MECKLENBURG COUNTY
Land Use and Environmental Services Agency

From: Dylan Kirk, Mecklenburg County LUESA
Date: Wednesday, May 27, 2020
Subject: City of Charlotte April Initial Rezoning Petitions

2020-057: Lakemont Property Investors, LLC

Schematic Site Plan Rezoning Petition #2020-057

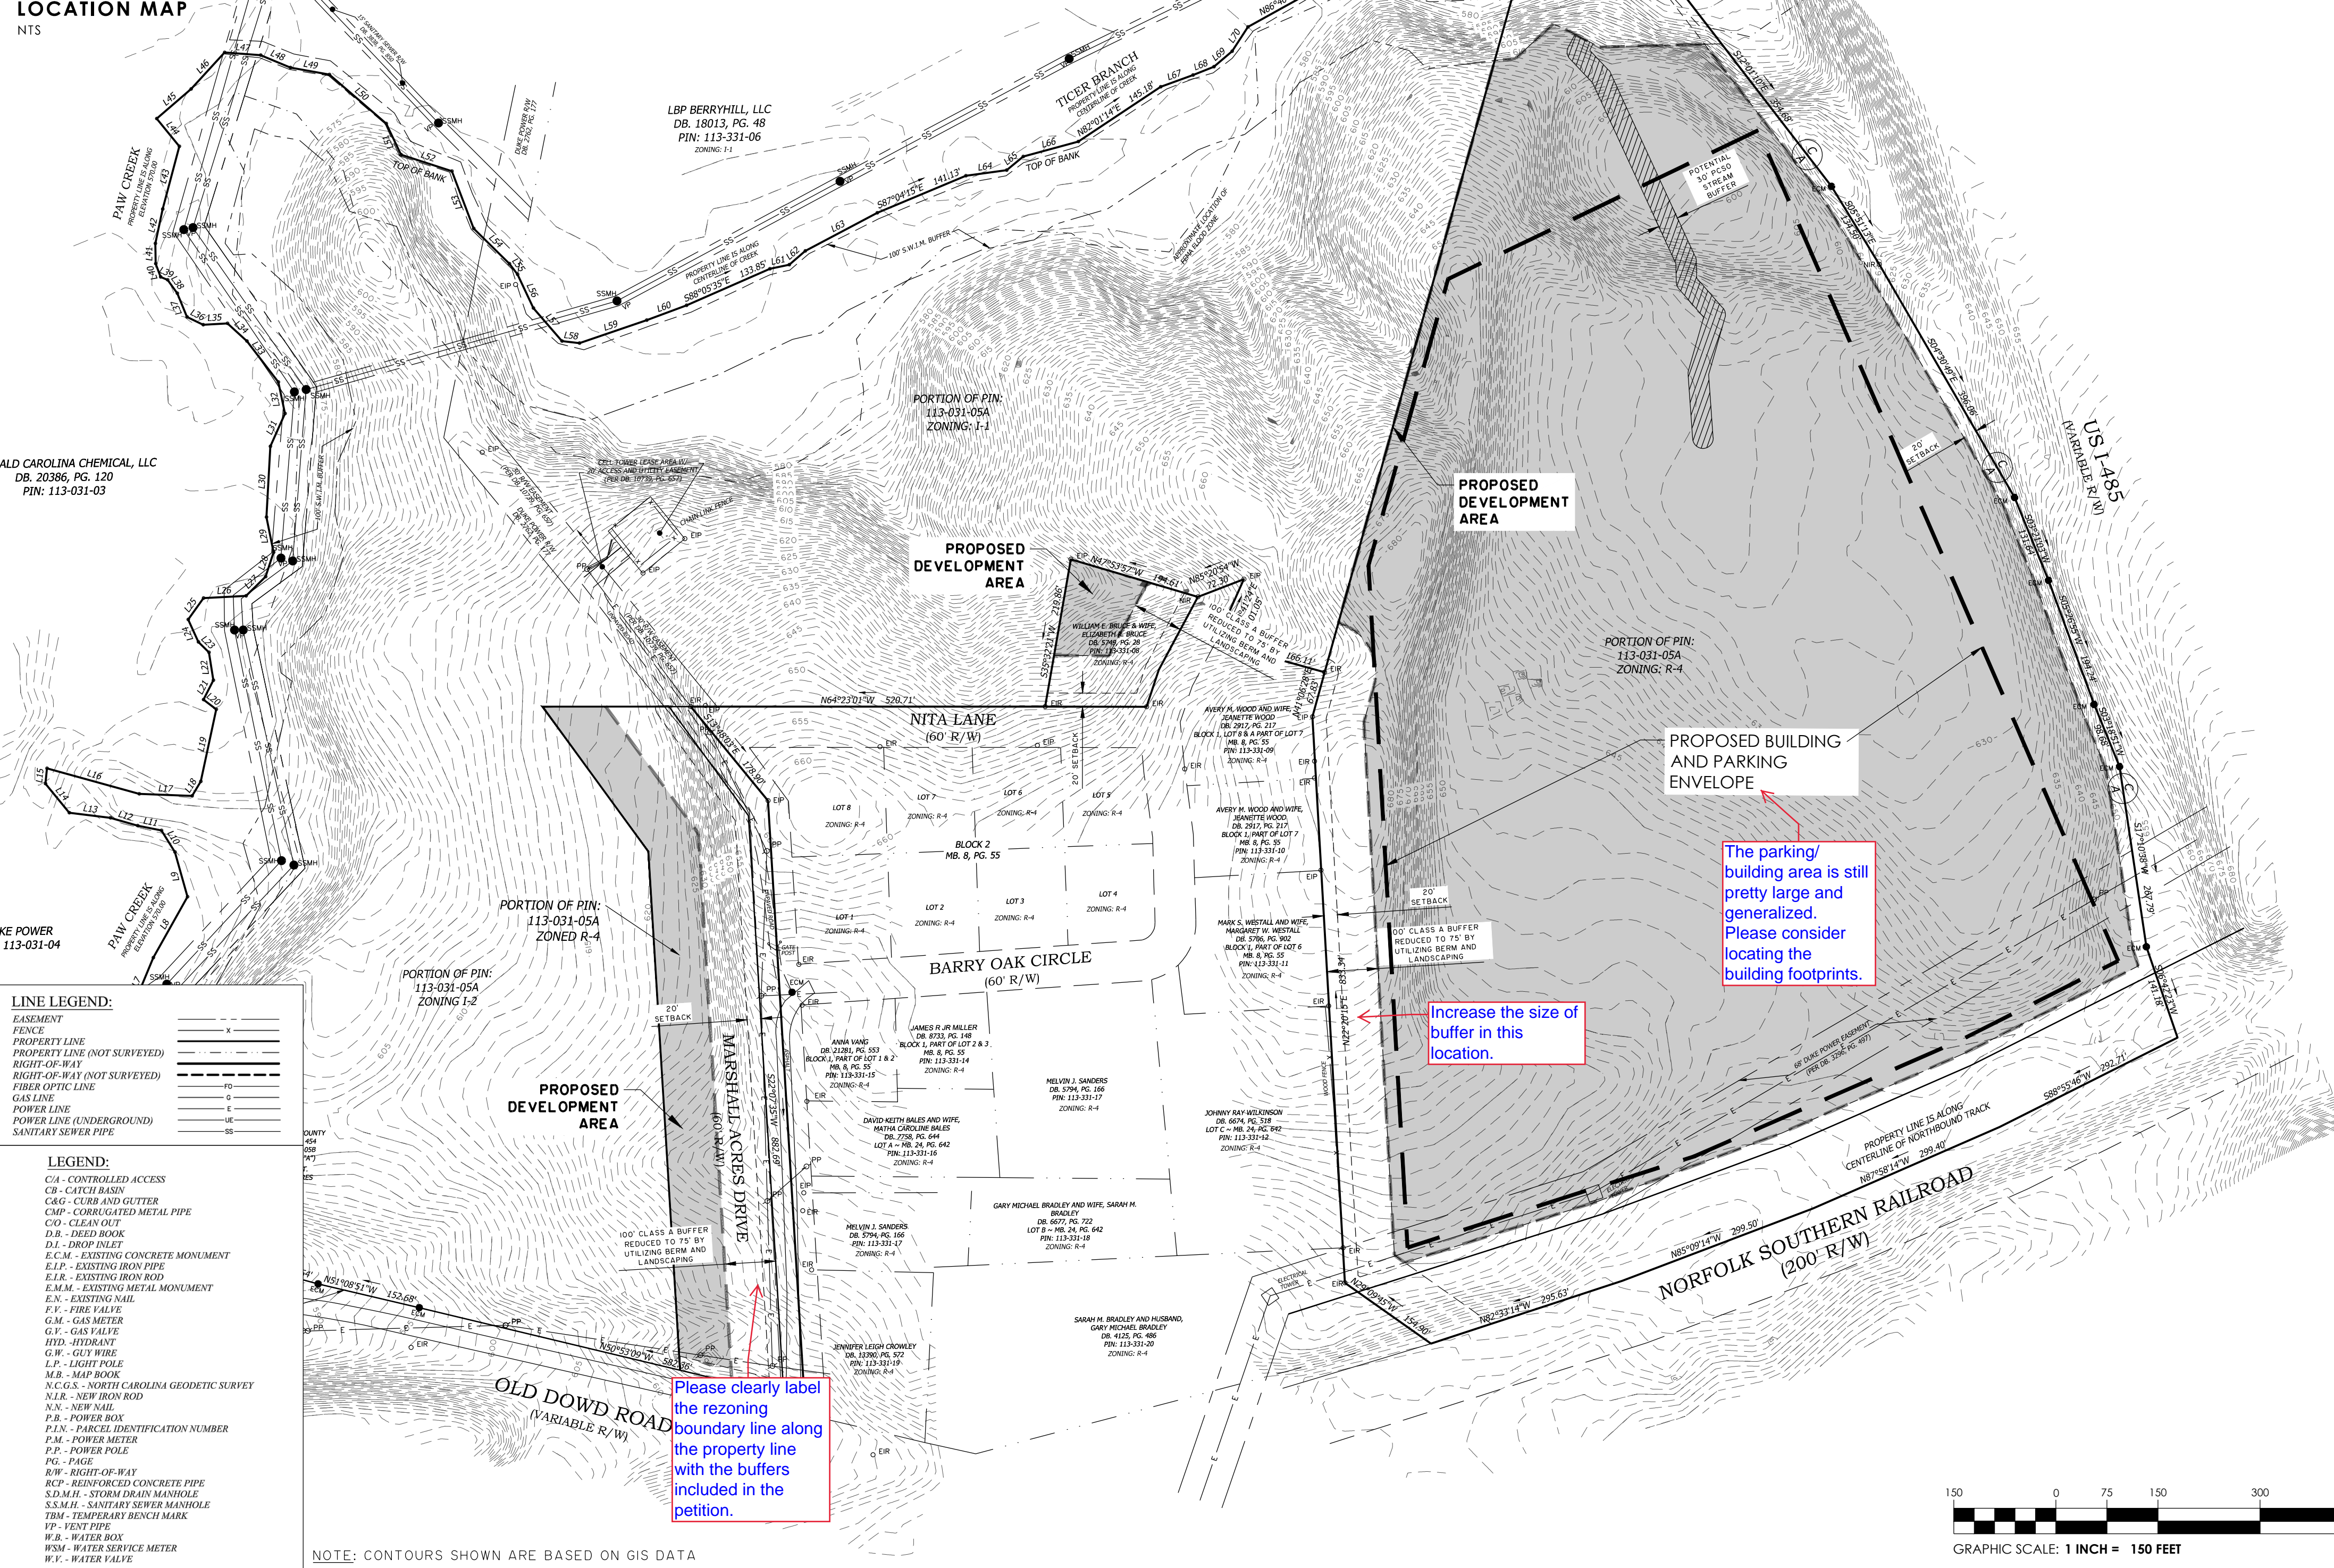
Ground Water Services Comments: A water supply well is registered as active drinking water well on parcel 113-031-05. GWS recommends that the petitioner identify any water supply wells within the project boundary and either protect the wells from damage by flagging and fencing during site development or permanently abandon the wells per the Mecklenburg County Groundwater Well Regulations prior to any demolition or grading activity occurring and conduct survey to locate the septic systems. A permit from GWS is required for permanent well abandonments. The abandonments must be completed by a North Carolina Certified Well Contractor. GWS records indicate a contamination site(s) exist on or within 1,500 feet of the properties included in the petitions. An established Area of Regulated Groundwater Usage (ARGU) as defined by the Mecklenburg County Groundwater Well Regulations extends 1,500 feet around the contamination sites. In ARGU where municipally supplied water is available water supply wells for water supply, irrigation or open loop geothermal systems may not be permitted or constructed on or within 1,000 feet of contamination sites. Wells may be permitted with special construction and sampling requirements between 1,000 and 1,500 feet of contamination sites. Where no other water sources are available, wells may be permitted with special construction and sampling requirements within 1,500' of contamination sites.

Storm Water Services Comments: A Floodplain Development permit must be obtained documenting compliance with the City of Charlotte Floodplain Regulations for all development occurring in the floodplain. In addition, staff recommend any structures proposed within the Community Special Flood Hazard Area be constructed to a Flood Protection Elevation equal to the Community Base Flood Elevation plus two (2) feet of freeboard based upon recent analyses of the future floodplains supported by the Storm Water Advisory Committee.
